# CITY OF ALBUQUERQUE

July 6, 2021

Re: **Chase Bank ATM**  
**11004 Montgomery Blvd NE**  
**Traffic Circulation Layout**  
Engineer's Stamp 07-02-2021 (G21-D018A(A))

CHASEO
PLOT DATE
08/27/21
DRAWING SCALE
1" = 20'
PROJECT NUMBER
CDC21003
SHEET NUMBER
C1.02

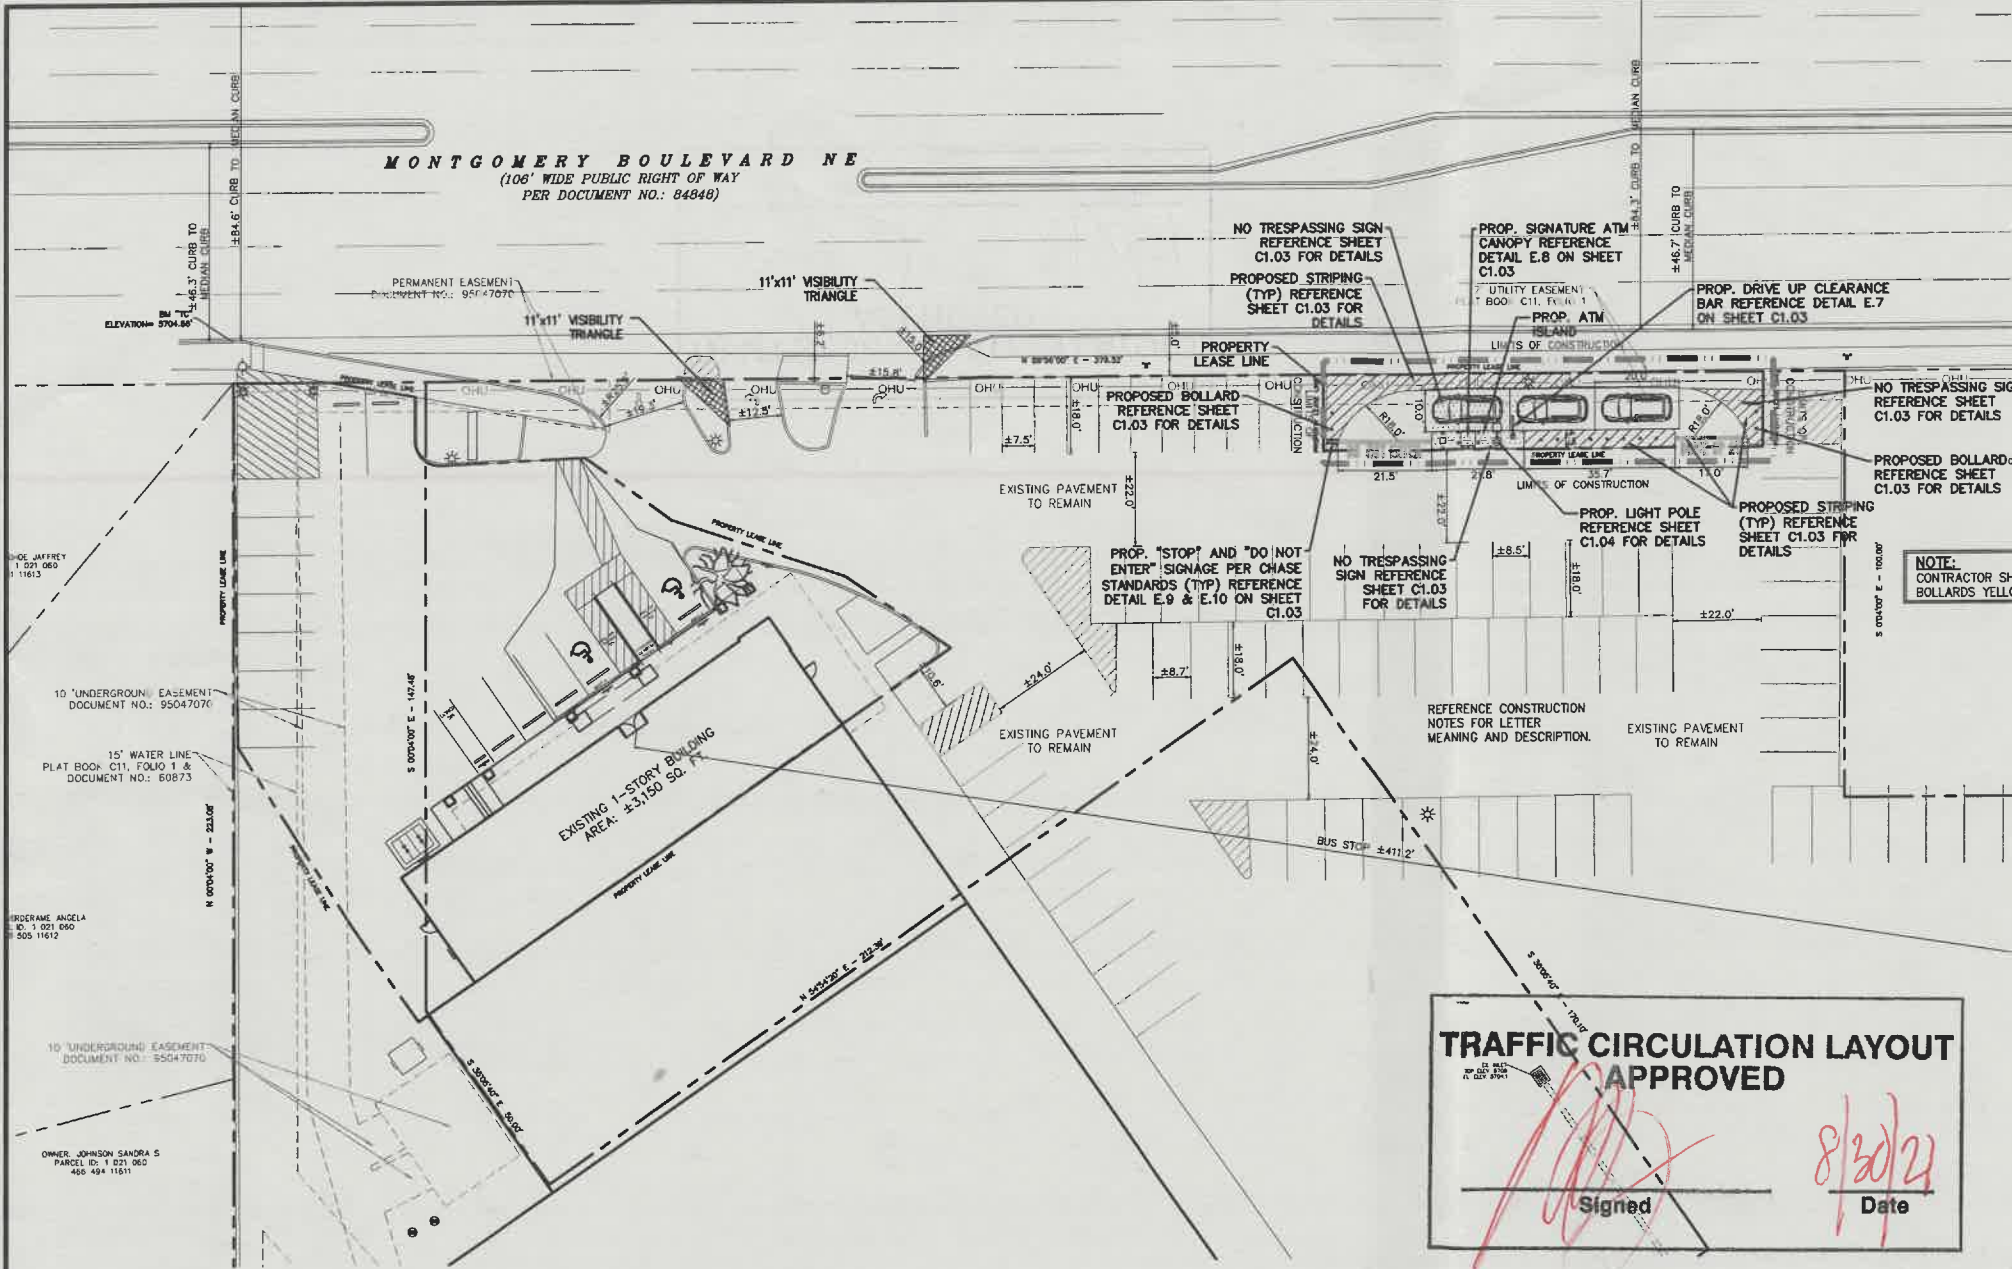
1. List the number of parking spaces required by the IDO as well as the proposed number of parking spaces including bicycle and motorcycle parking. Coordinate/discuss with Zoning with the calculations listed on site plan to substantiate the removal of parking stalls to construction ATM infrastructure.

4. Provide a bollard detail proposed on sheet C1.02.
5. All proposed striping will need details (stripe color, thickness & spacing between stripes).
6. Any safety concern with free standing NO TRESPASSING sign without curbing on the departure of ATM. Please address this concern.

7. You have a symbol that appears to be light pole but no detail. Provide detail.
8. Any problems with stacking over flow interfering with existing parking stalls and drive aisle? Please address.
